## Fire Marshal Division

**RE: Harnett Central Crossing Foodmart  
4858 NC Hwy 210 N  
Lillington, NC 27546**

**Re: Application Number – BCOM1812-0005**

LIFE SAFETY PLAN

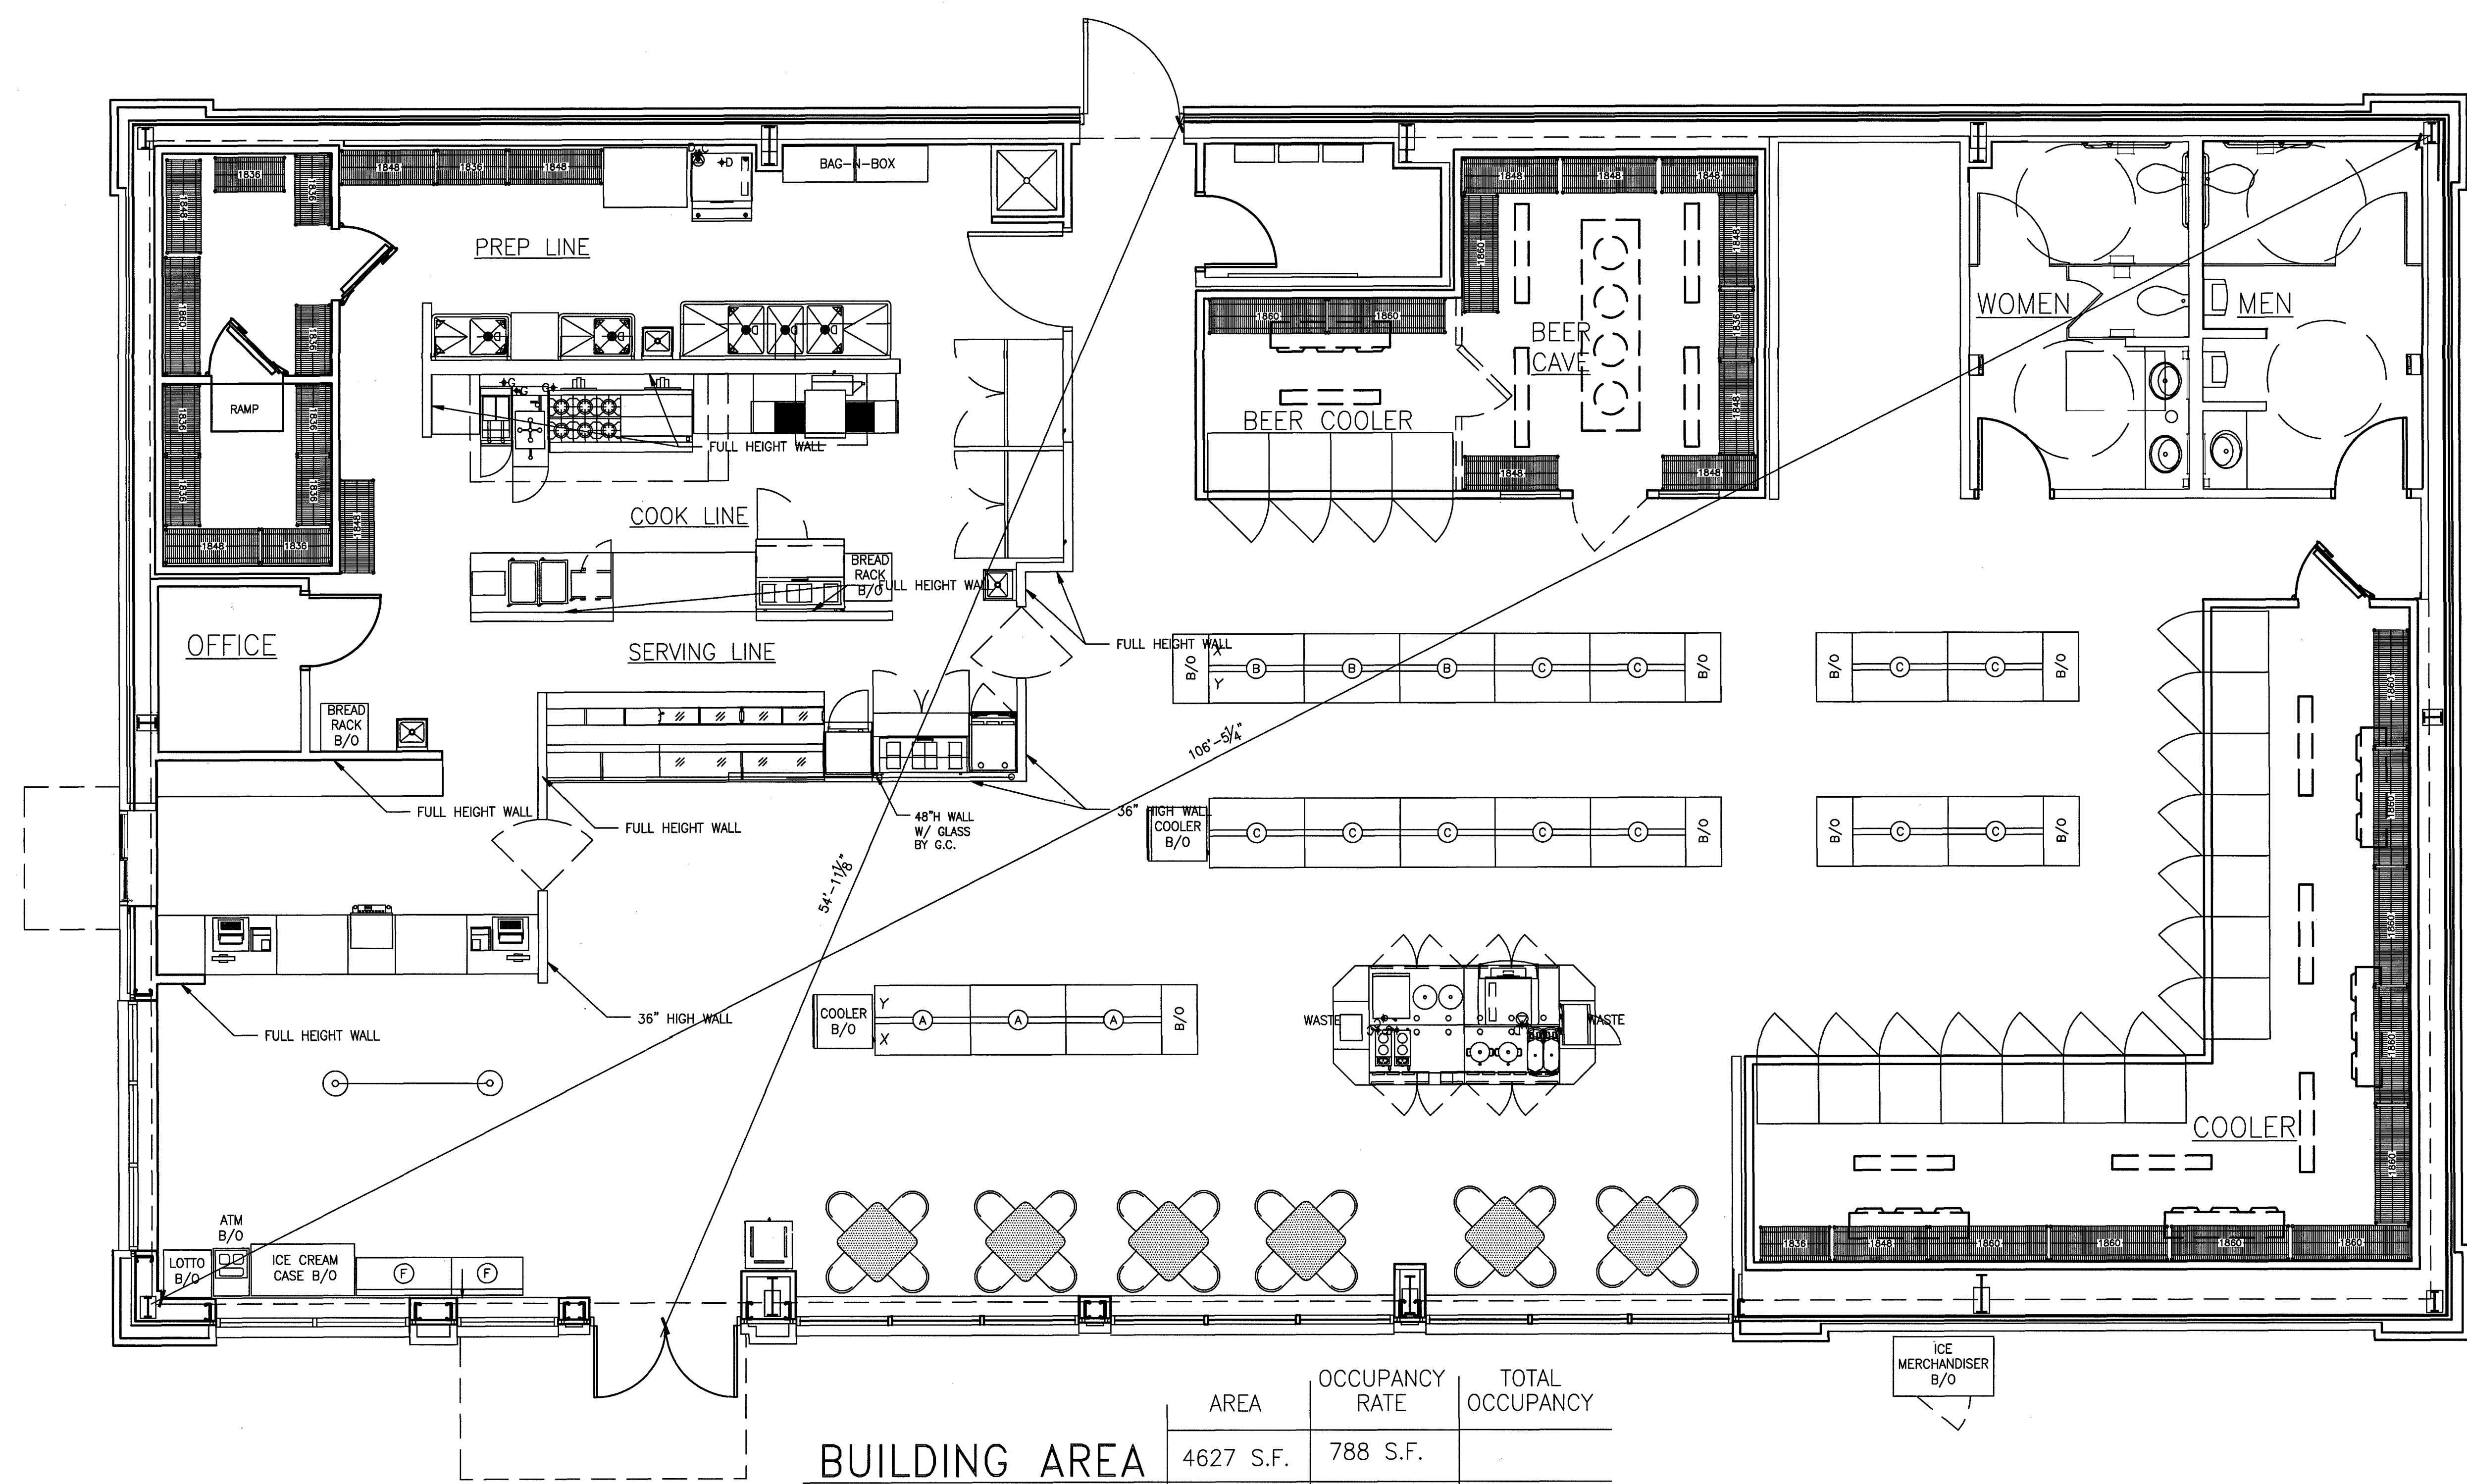
- **906.1 Fire Extinguishers**
  - Fire extinguishers shall be placed in approved locations and may be field verified on final inspection. The fire extinguishers provided shall have a minimum rating of 2A 10 B: C. Fire extinguisher shall be installed not to exceed 75' distance of travel.
  - A 2A 10B: C shall be installed not to exceed 75' distance of travel from motor fuel dispensing equipment.

- **Notes**
  - A set of construction documents will be required prior to approval including a life safety plan.
  - Fixed fire suppression system will require additional permit.
  - Please contact the Fire marshal's office to schedule fire suppression acceptance testing, UGST, underground piping and fire final inspection when work is complete.
  - Harnett County Fire Marshal's Office 910-984-4003
